OBJECTION TO PLANNING APPLICATION

Tirawley Wind Farm, Parish of Lacken, Co. Mayo

Case Reference: PAX16.324258 | An Coimisiún Pleanála

APPLICANT:	Constant Energy Limited
DEVELOPMENT:	16 × Vestas V117 4.3 MW Wind Turbines + 150 MW BESS, 20 Units
SUBMITTED BY:	Liam Donoghue, Receptor H45, Parish of Lacken, Co. Mayo Carrickanass, Carrowmore Lacken, Ballina, Co. Mayo, F26 R9C2 liam.donoghue@yahoo.ie
FOLIO:	MY85163F
DATE:	25 June 2026
CASE NUMBER:	PAX16.324258

Drawing file: 2000 - BESS / 6289-PL-2001 PROPOSED BATTERY STORAGE FACILITY COMPOUND, ELEVATIONS - SECTION.pdf

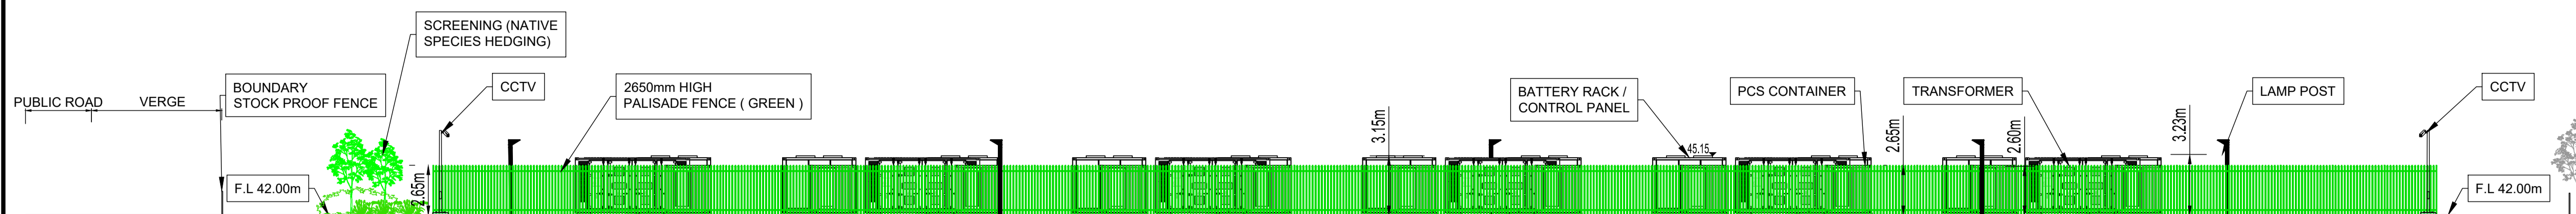
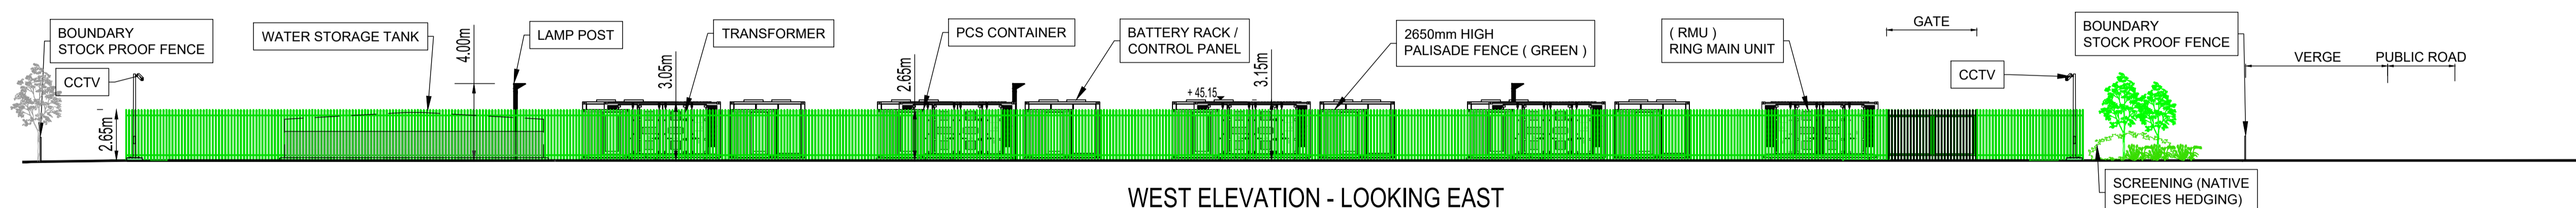
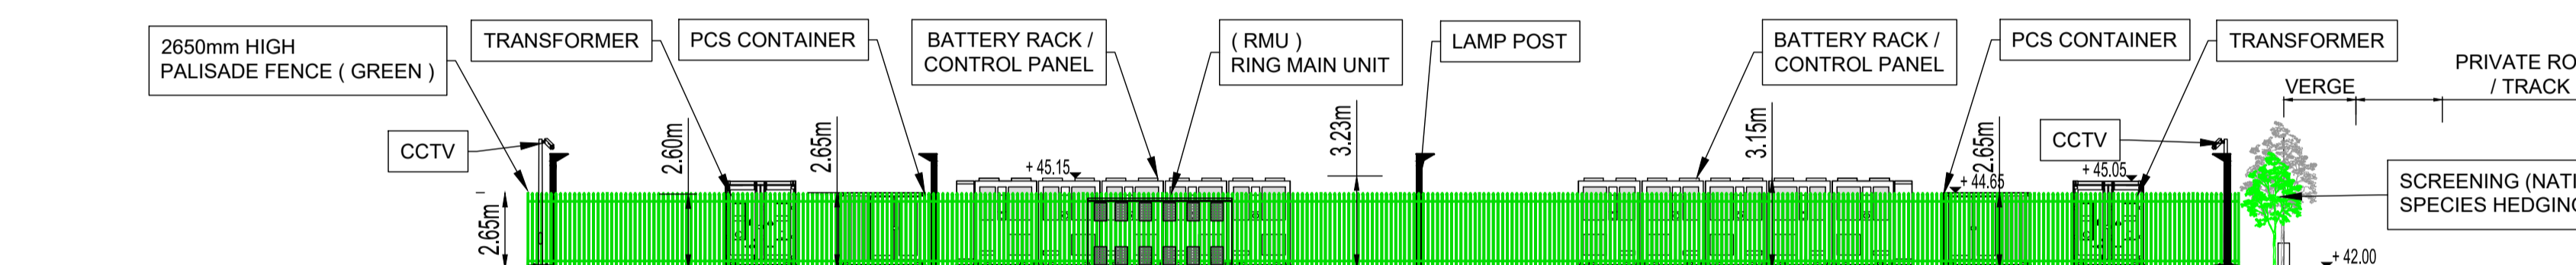
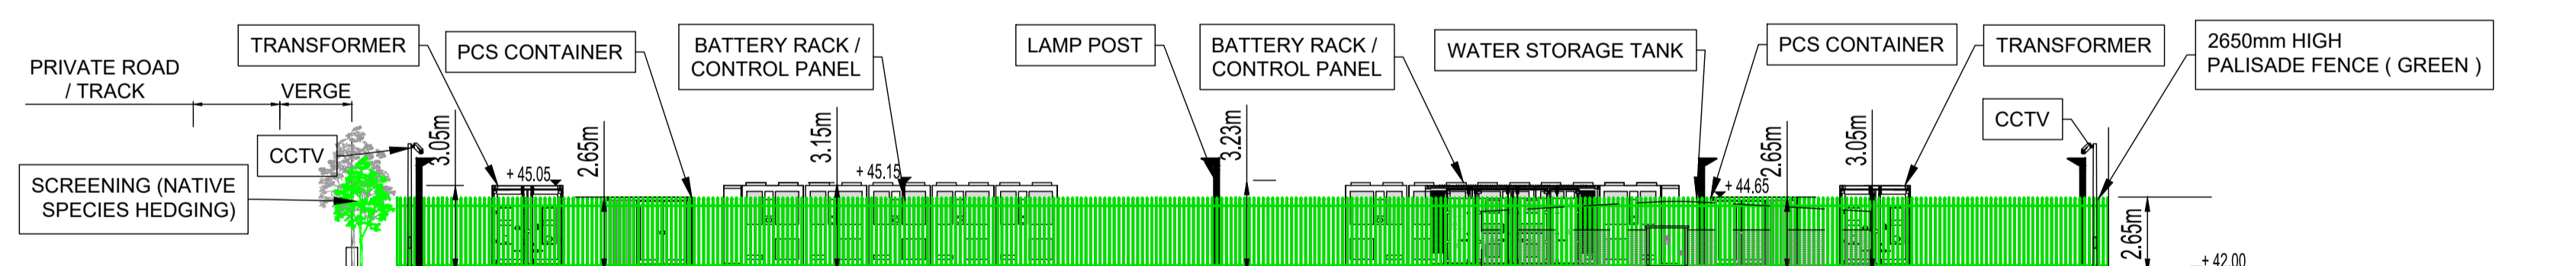
The defect: The proposed BESS installation consists of 20 battery container units with a collective energy storage capacity of up to 150 MW. Lithium-ion battery storage systems of this scale can trigger obligations under the Control of Major Accident Hazards (COMAH) Regulations 2015 (S.I. 209/2015), which transpose the Seveso III Directive (2012/18/EU) into Irish law.

Proximity to H45: The BESS installation is situated 512 metres due north of the Objector's residence. No consequence modelling — dispersion modelling, fire plume analysis, toxic gas transport modelling — has been carried out to assess the impact of a BESS fire event at this distance on residential receptors.
